From: Ken Edwards <Ken.Edwards@kittitaspud.com>
Sent: Tuesday, June 4, 2024 10:50 AM
To: Bradley Gasawski
Subject: RE: AU-24-00002 Henke - Notice of Application

RE: AU-24-00002 Henke

TO: All Staff
FROM: Public Works Plan Review Team
DATE: June 18th, 2024
SUBJECT: AU-24-00002 Henke

PROPOSED SITE PLAN

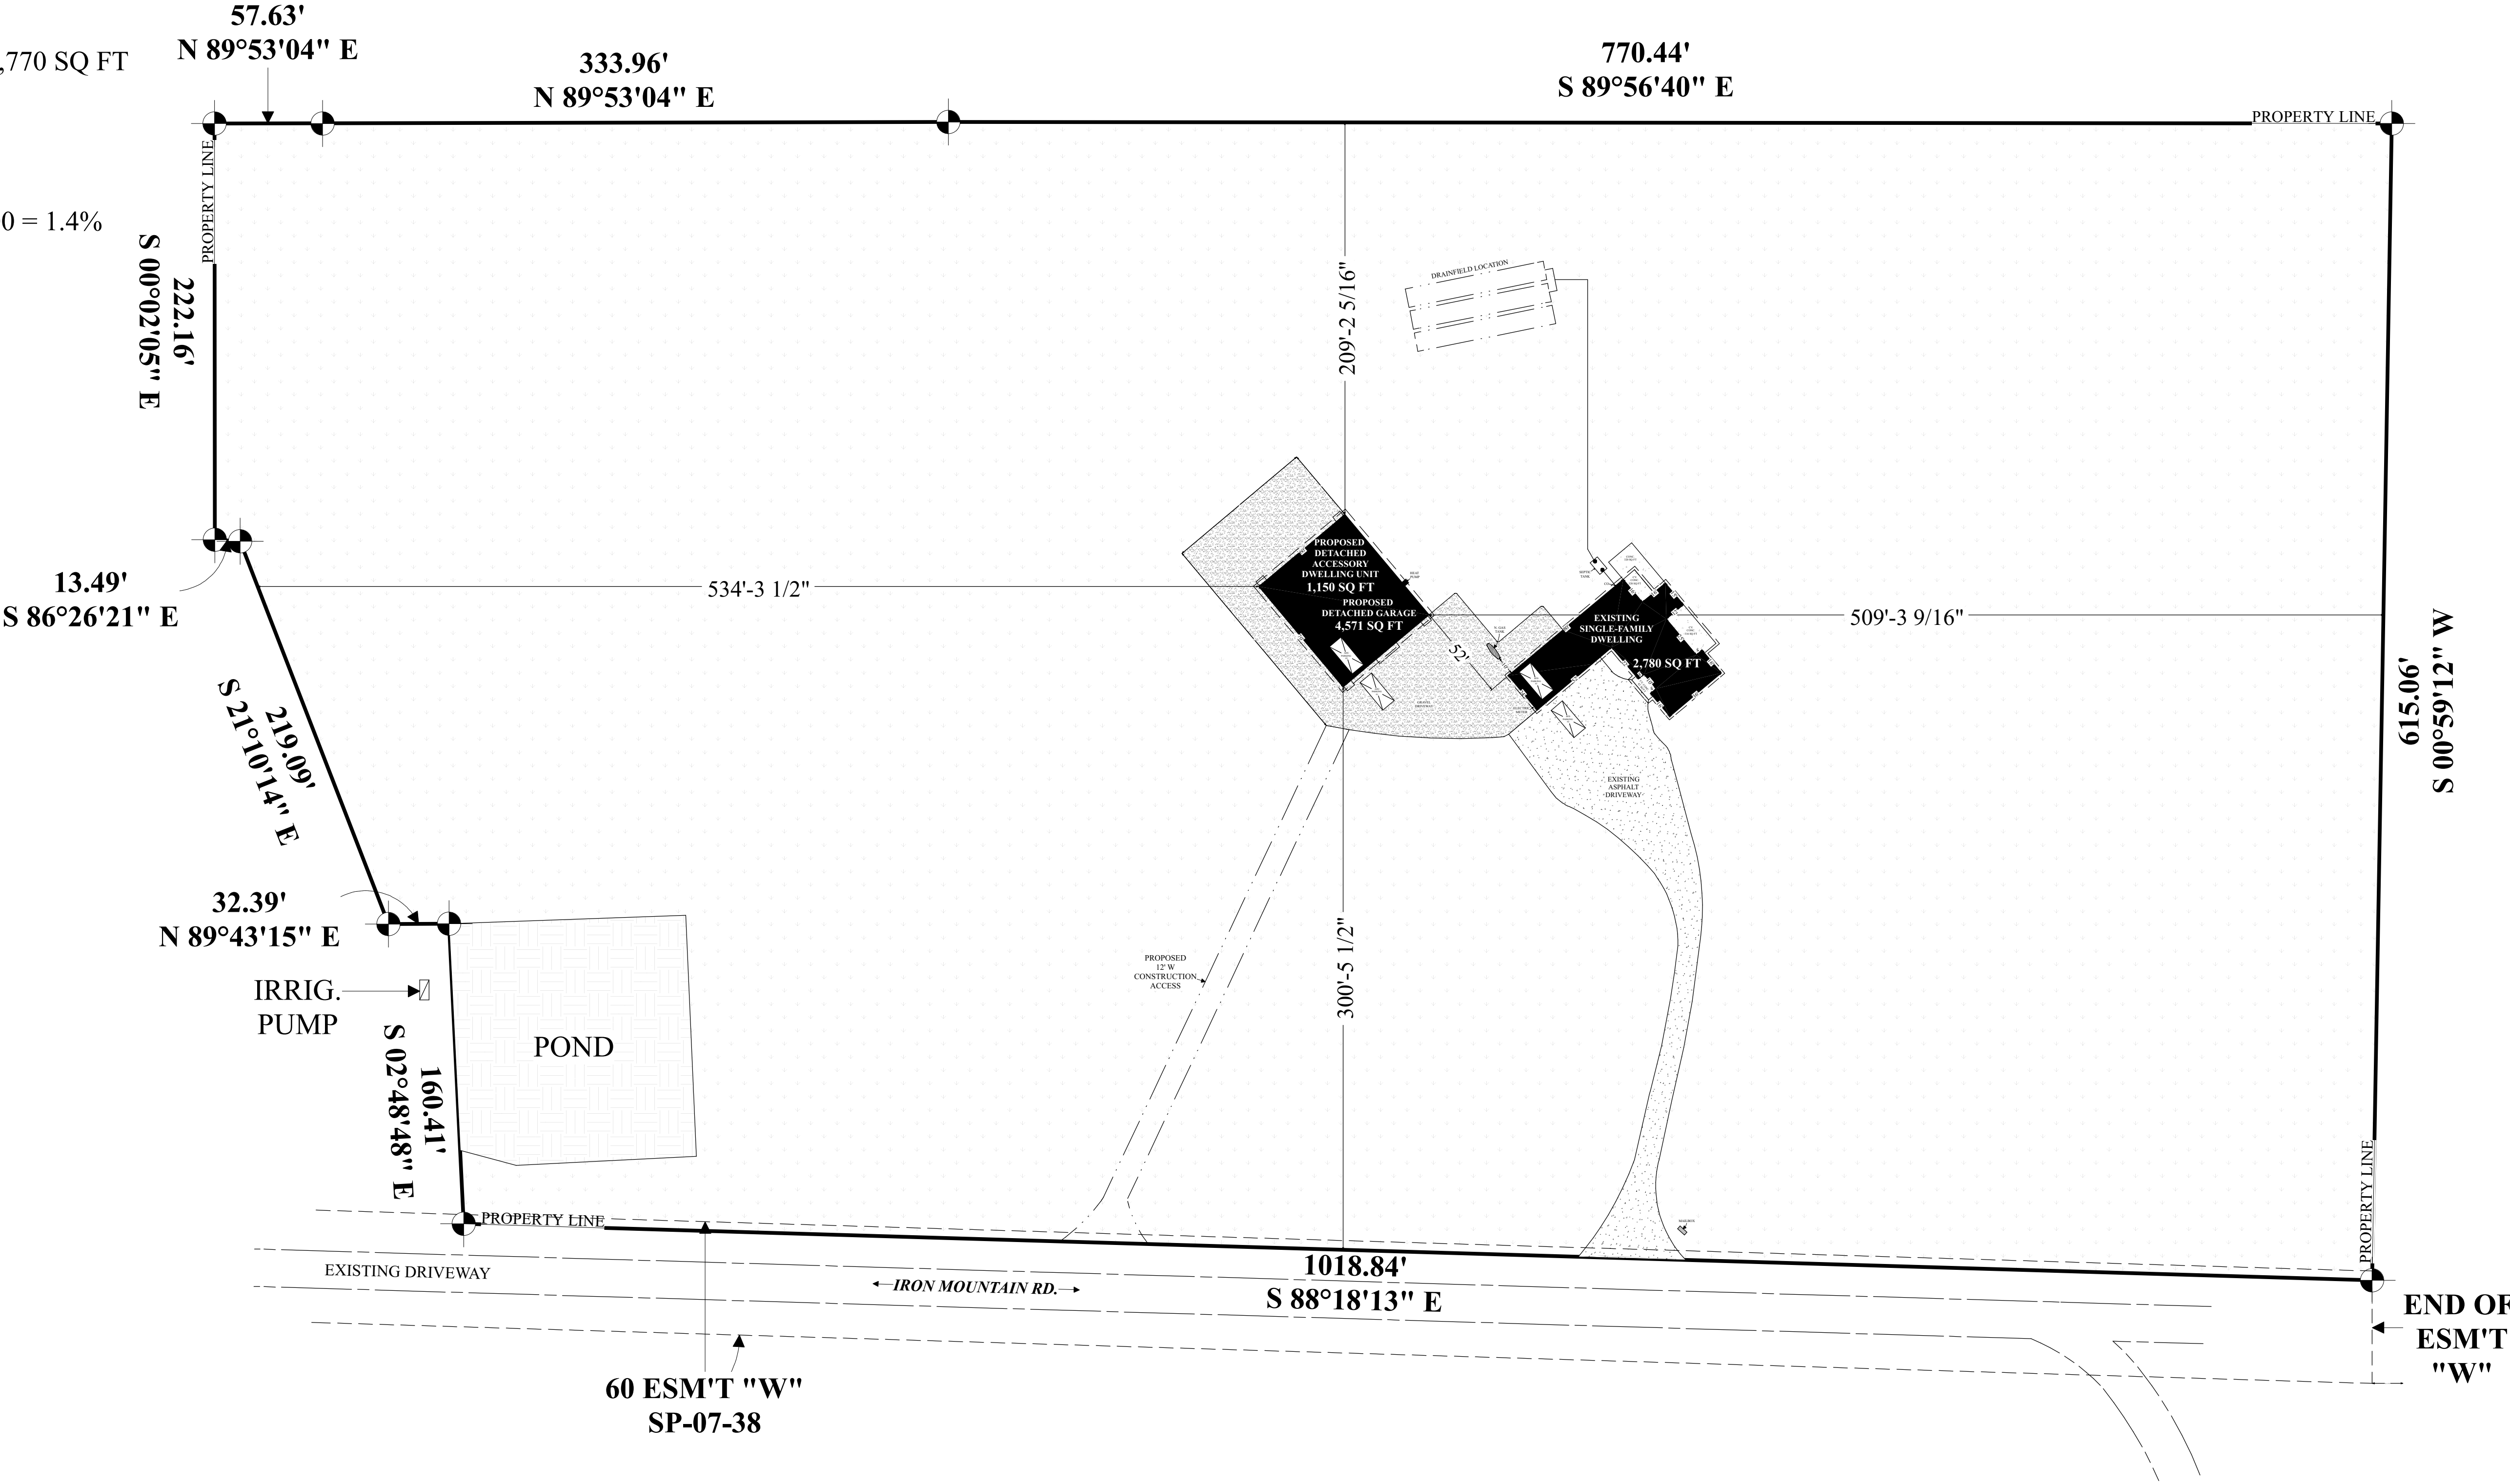
Driveways in excess of 150' shall have a turnaround at the terminus that meets the requirements of the International Fire Code Appendix D.
